Drainage Report Final_V1.pdf Markup Summary

TRI-STATE GENERATION & TRANSMISSION, INC.

FOX RUN SUBSTATION DRAINAGE REPORT

SHEET NO. A-1

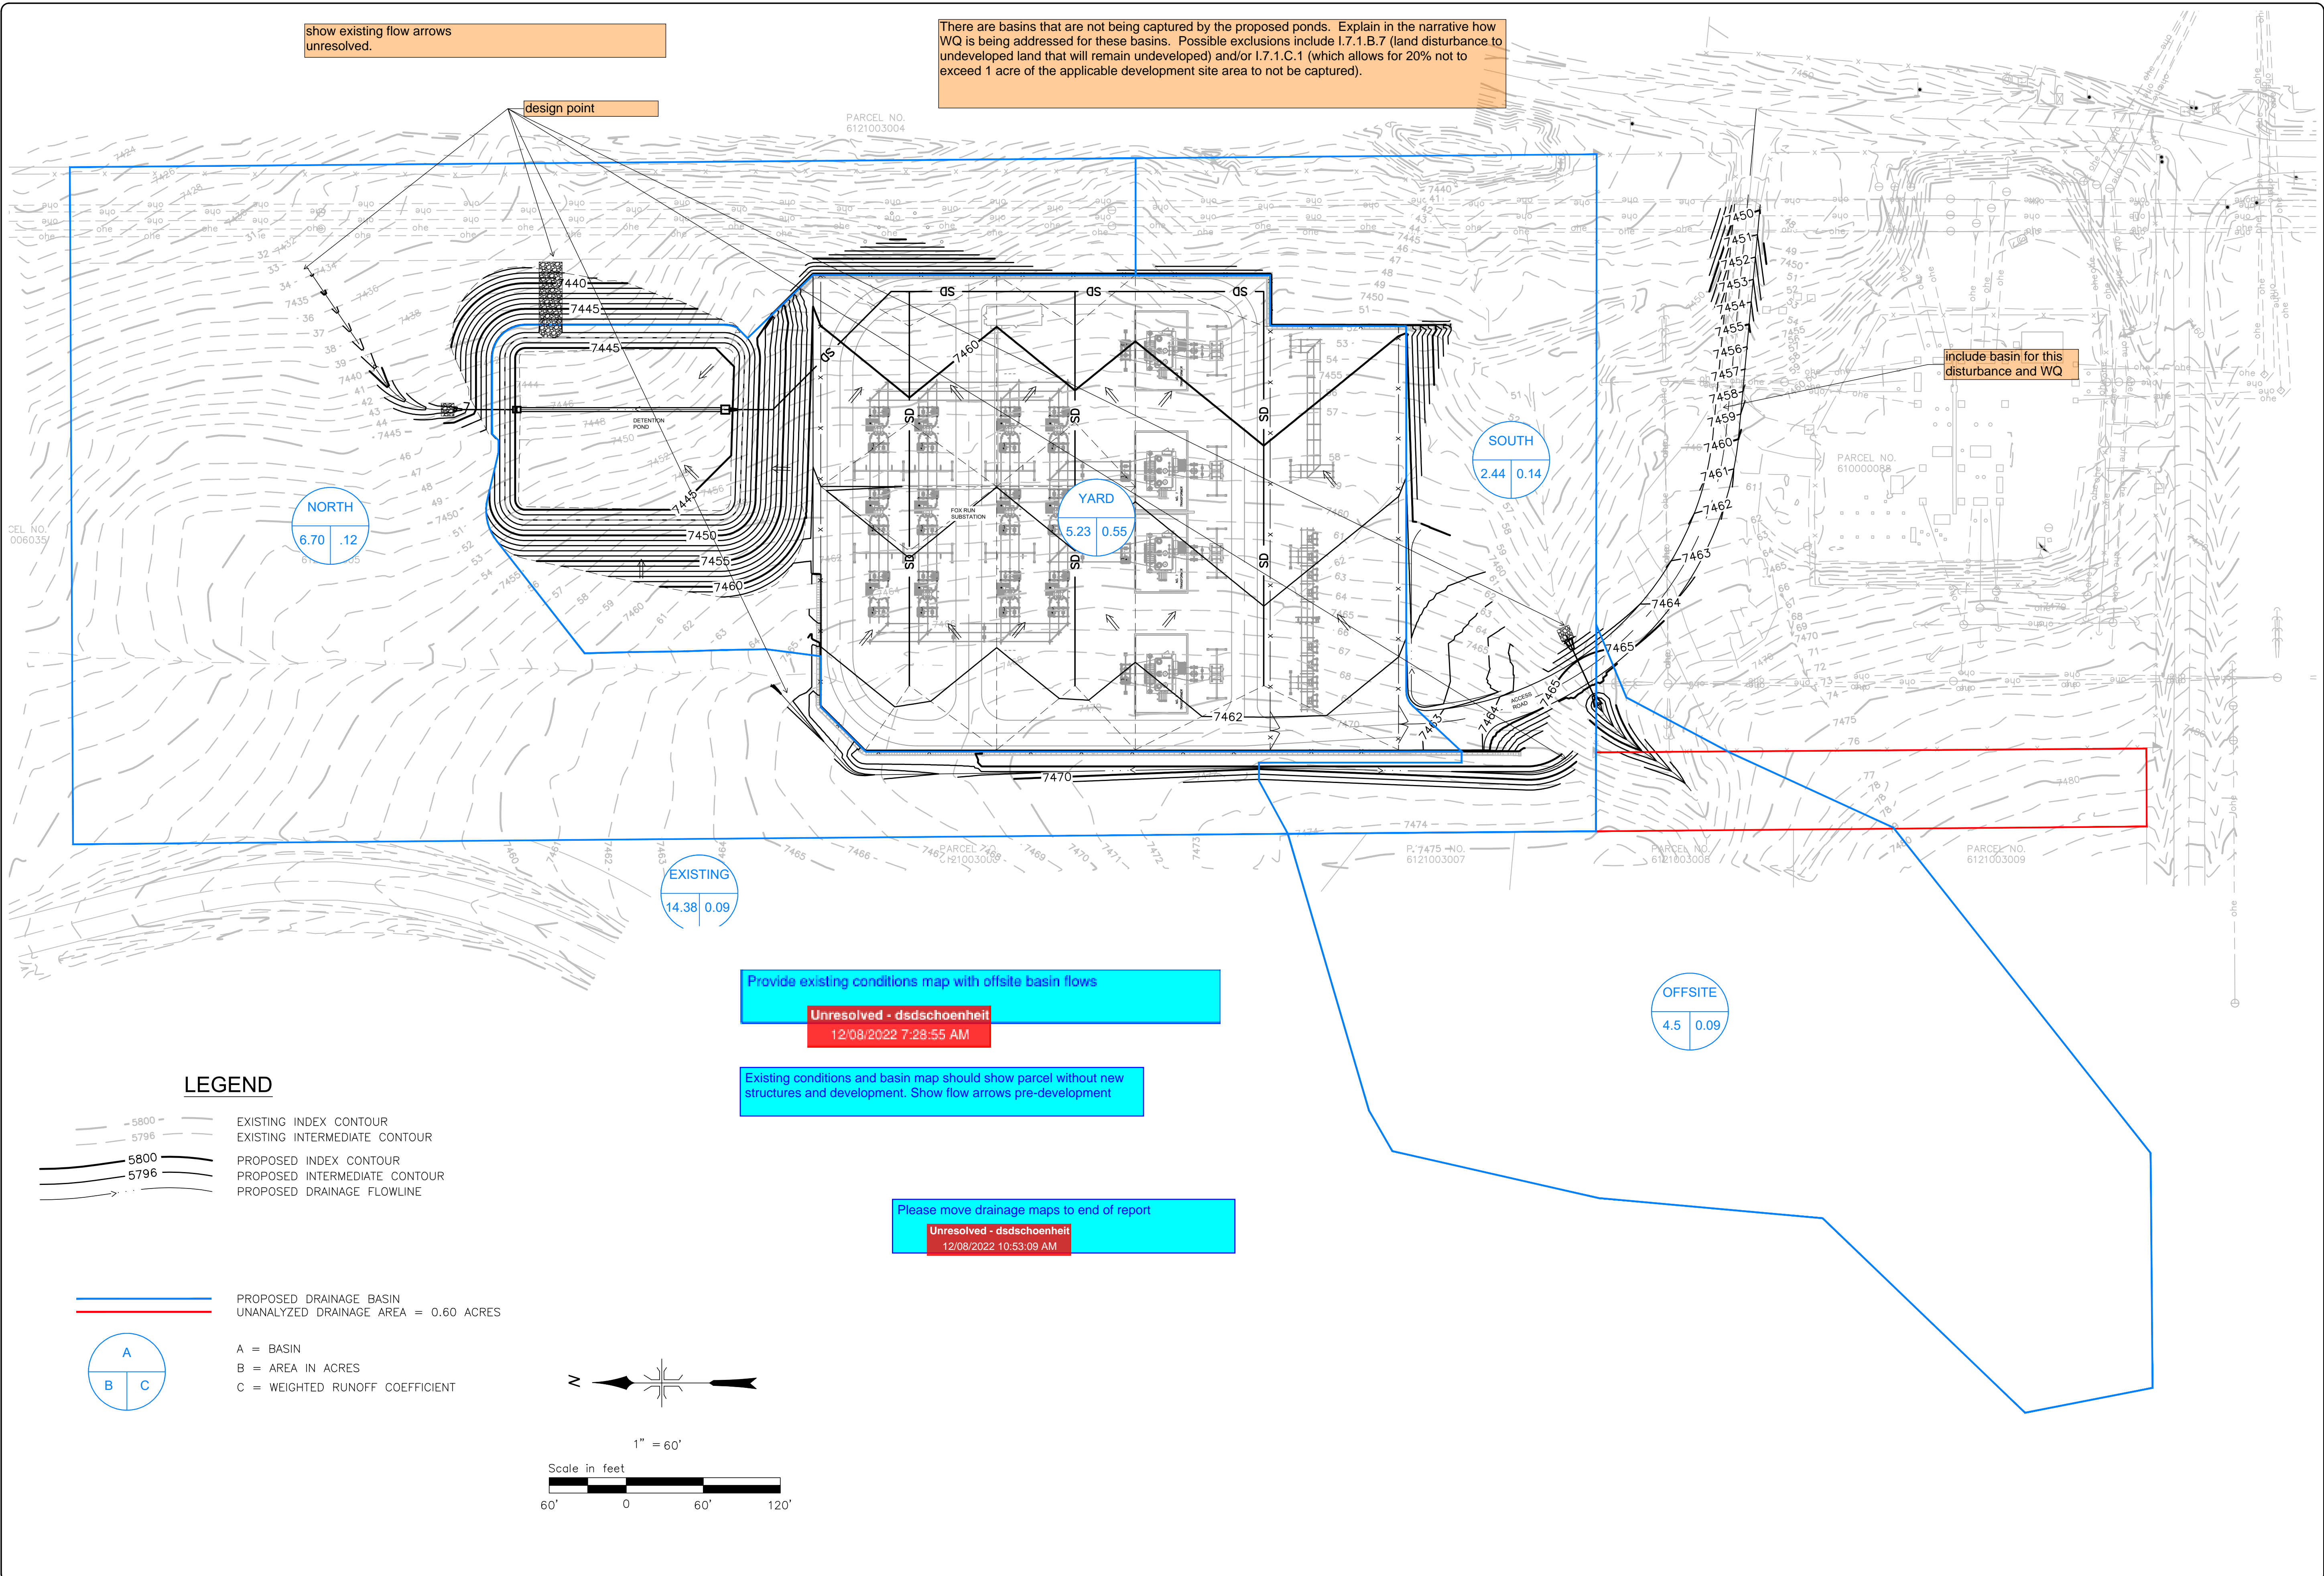
Provide discussion of offsite drainage flow patterns and their impact on the development and show on an existing conditions drainage map

Provide existing conditions map with offsite basin flows

show all existing and proposed flow arrows. how will the flow be directed towards the pond?

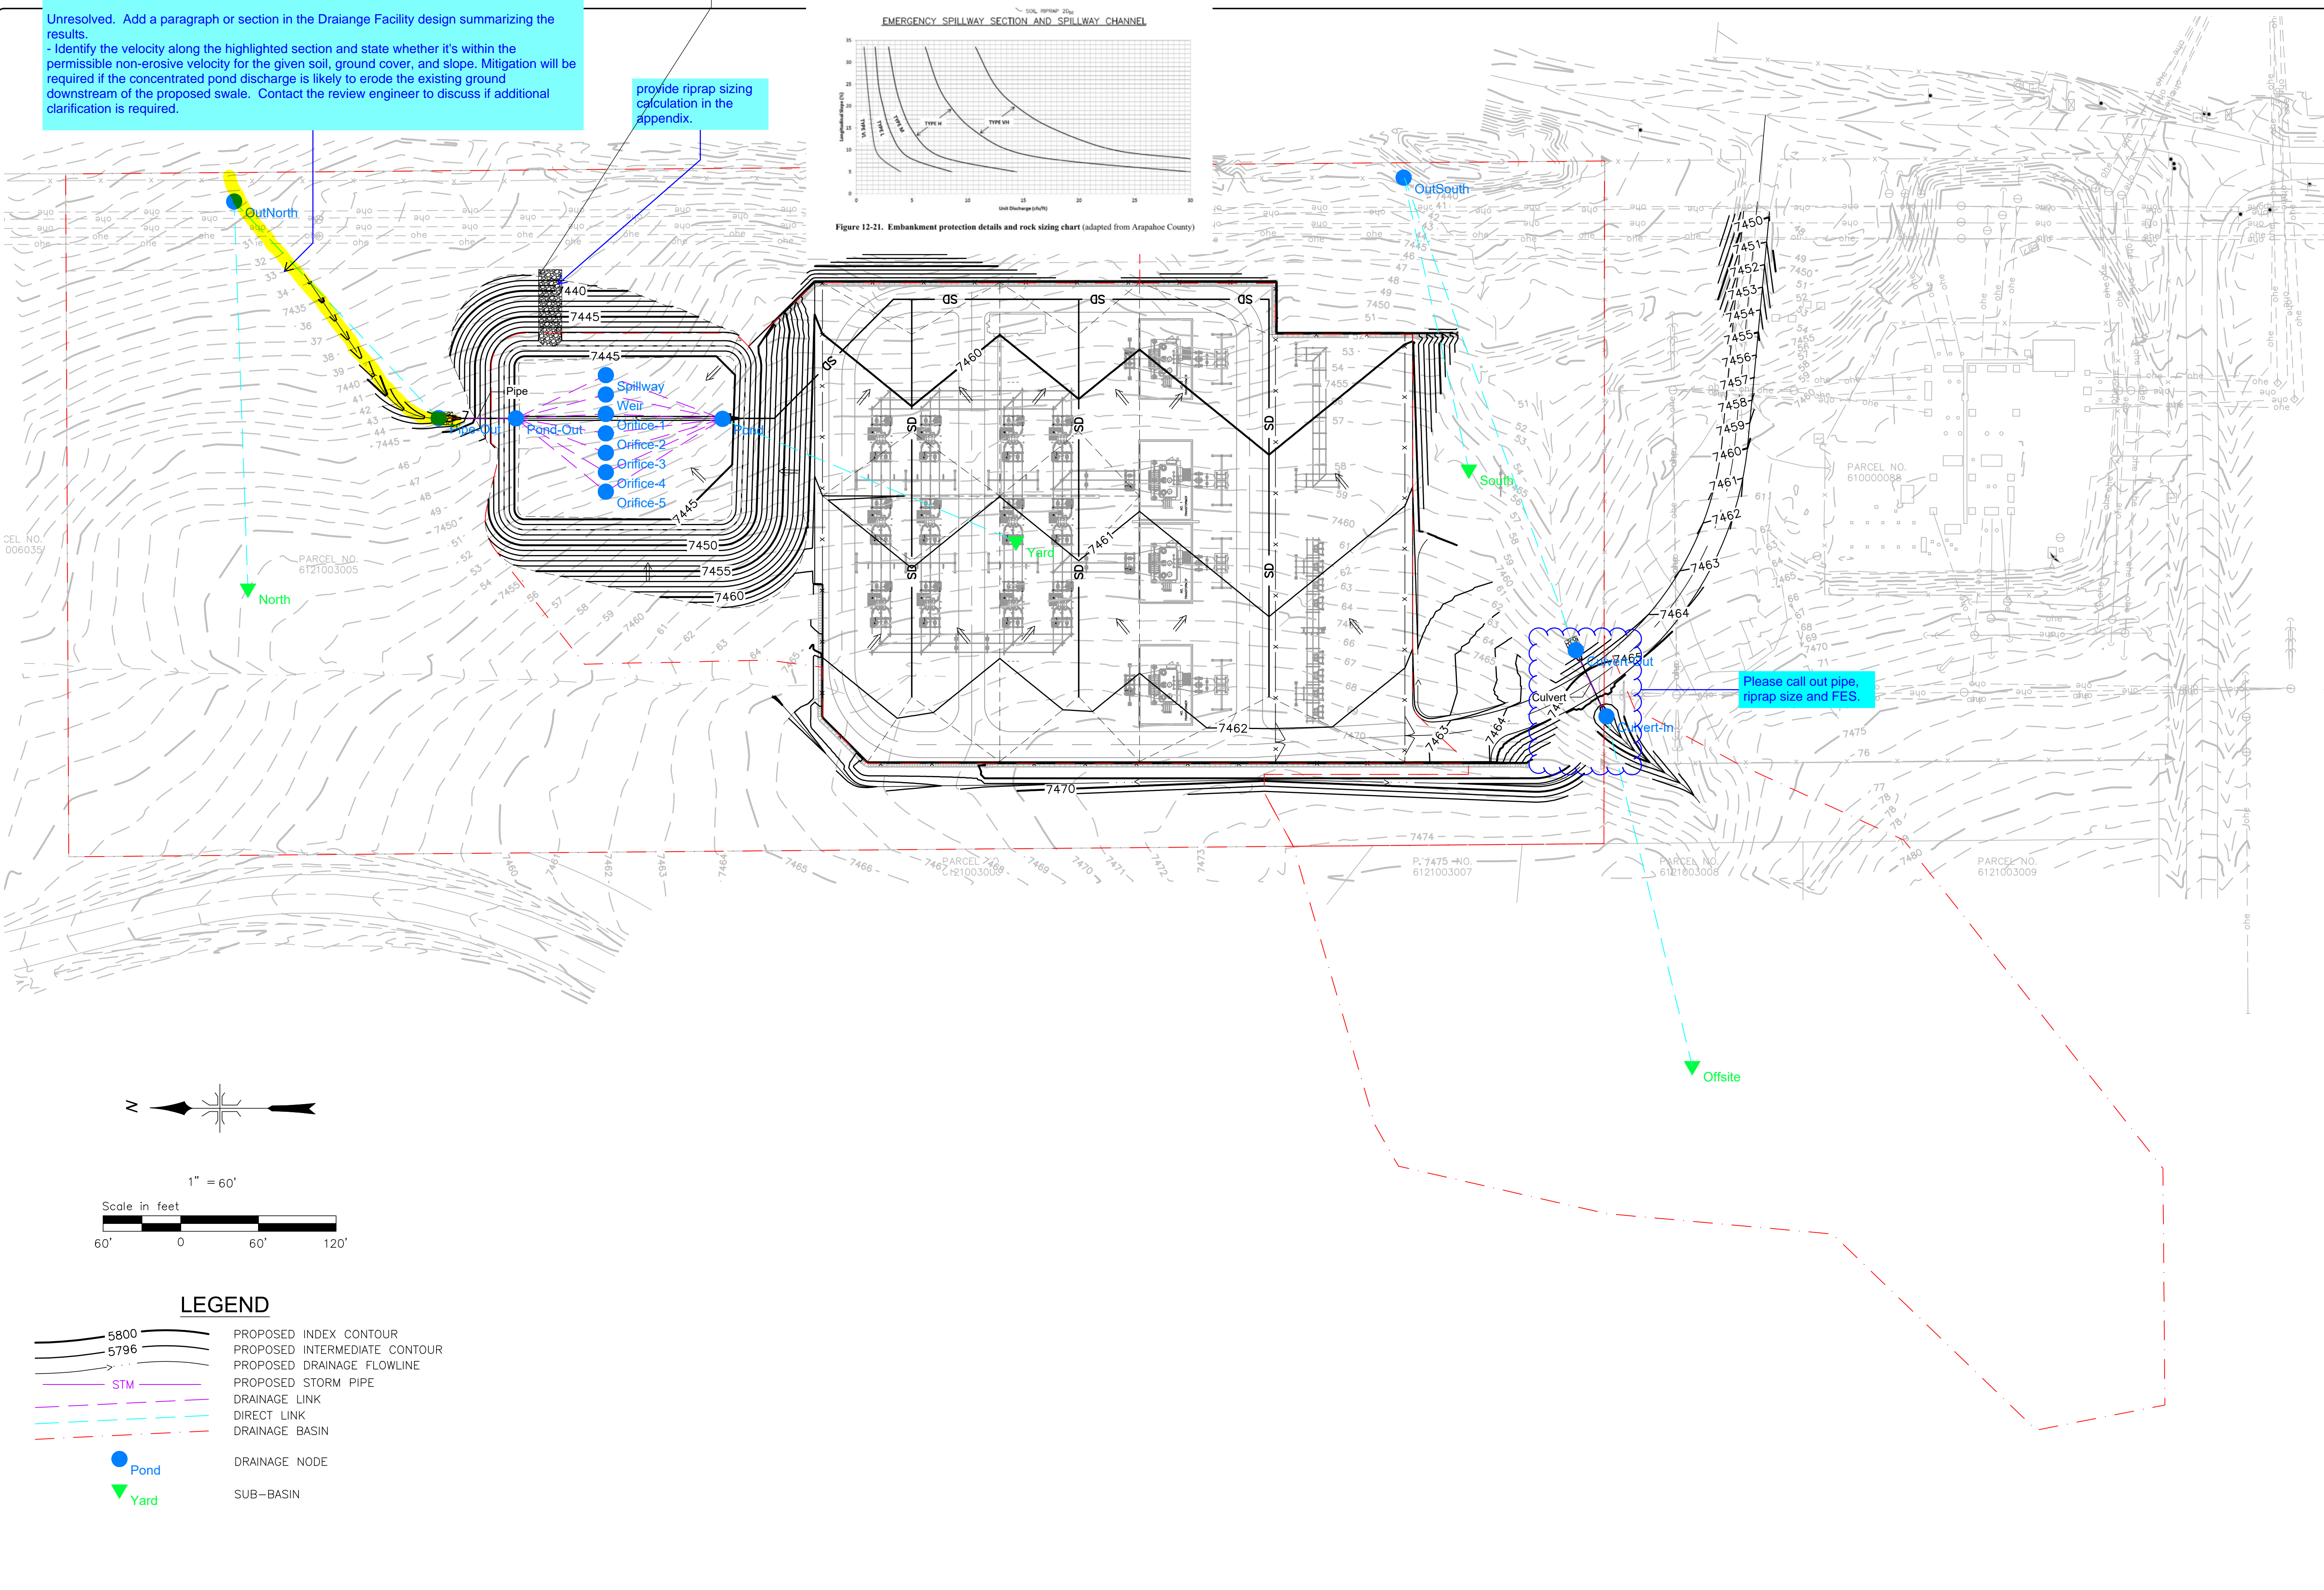
Subject: Callout Page Label: 13 Author: dsdlaforce Date: 8/23/2022 12:40:18 PM Status: Color: Layer: Space: The manner of flow has changed from sheet flow to concentrated flow. Analyze the conveyance path up to the suitable outfall as defined in ECM 3.2.4. The conveyance path must be hydraulically adequate/stable.

Show emergency spillway and overflow path.
